Project Name: NORTH ALBUQUERQUE ACRES

DATE: February 5, 2004
TO: Sheran Matson, Planning Department
FROM: Jim Joseph, P.E.
SUBJECT: Lots 31 and 32 in North Albuquerque Acres, Tract A, Unit B, Block 5 (Current DRB Project No.1003173 [1/28/04 Agenda]).

**CITY OF ALBUQUERQUE
PLANNING DEPARTMENT
Development Review Board
January 28, 2004
Comments**

RE: Verano Plaza/Prelim & Final plat

Plat of
Lots A, B, C, D and E
Verano Plaza
Albuquerque, Bernalillo County, New Mexico
January 2004

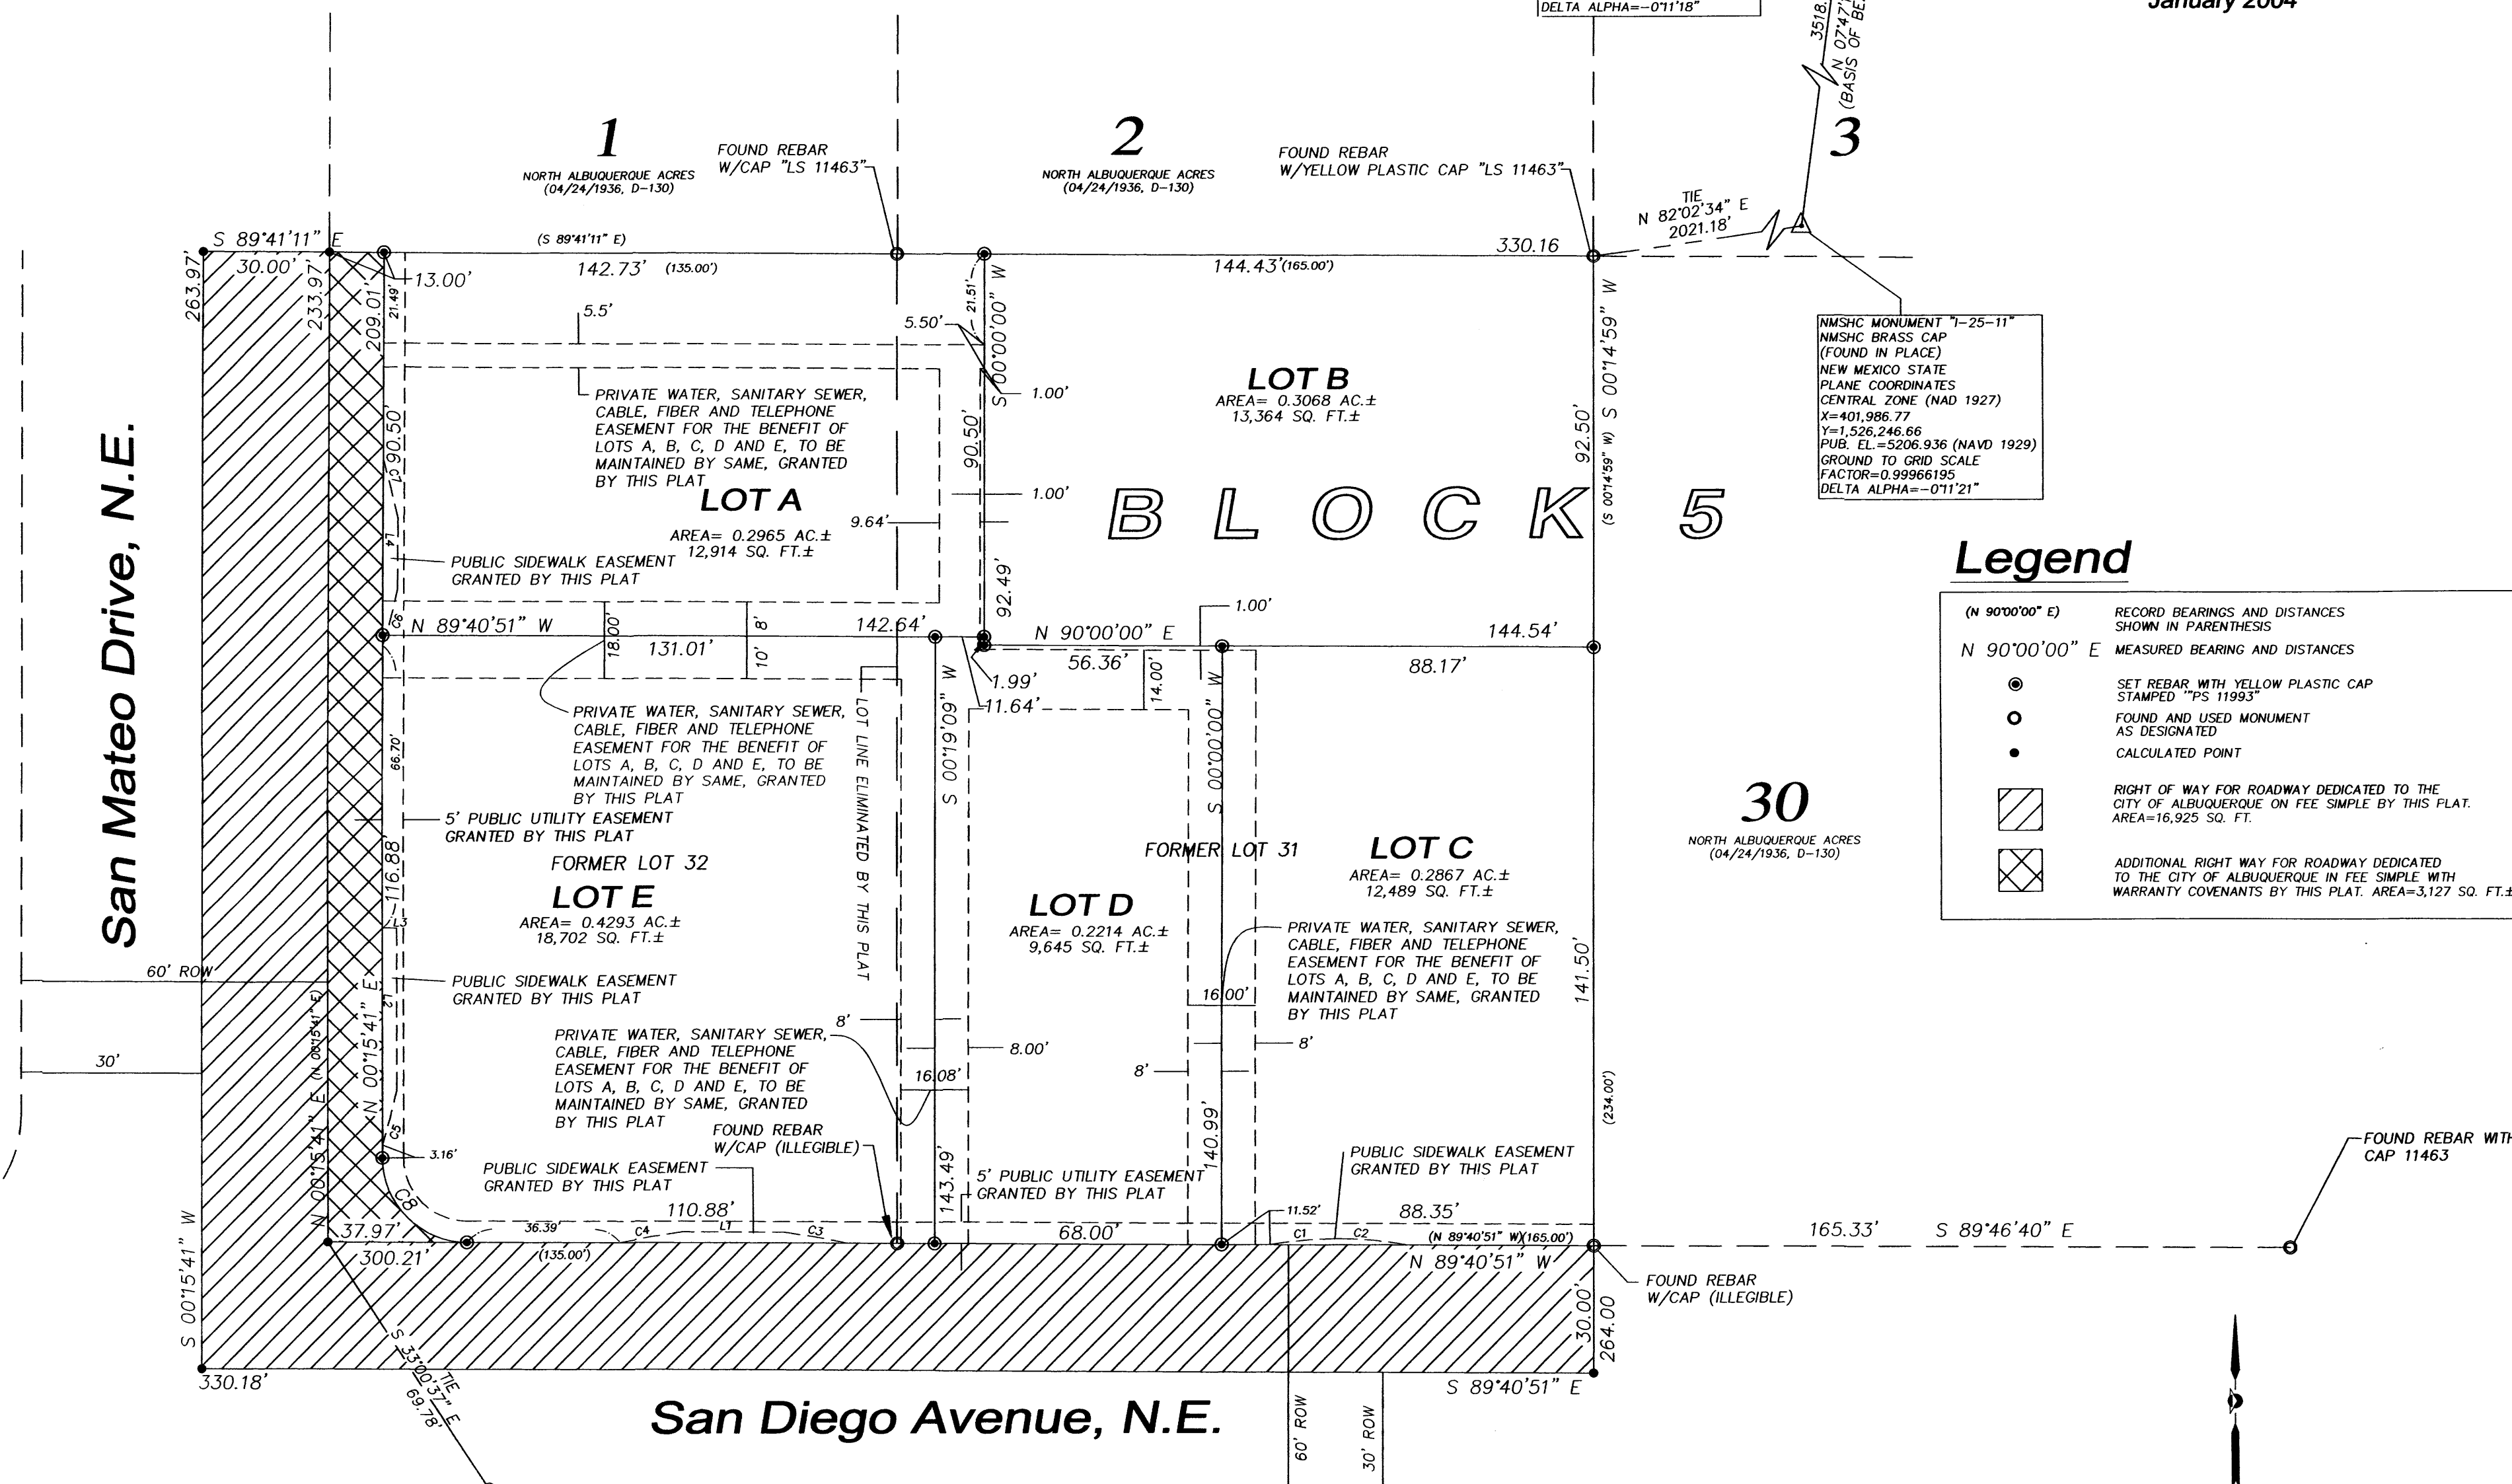
The plat appears to match the site plan for building permit.

An approved drainage report is required for Preliminary Plat approval.
 An approved Subdivision Improvements Agreement with financial guarantees is required for Site Development Plan sign-off.
 Need cross-lot drainage easements on plat.
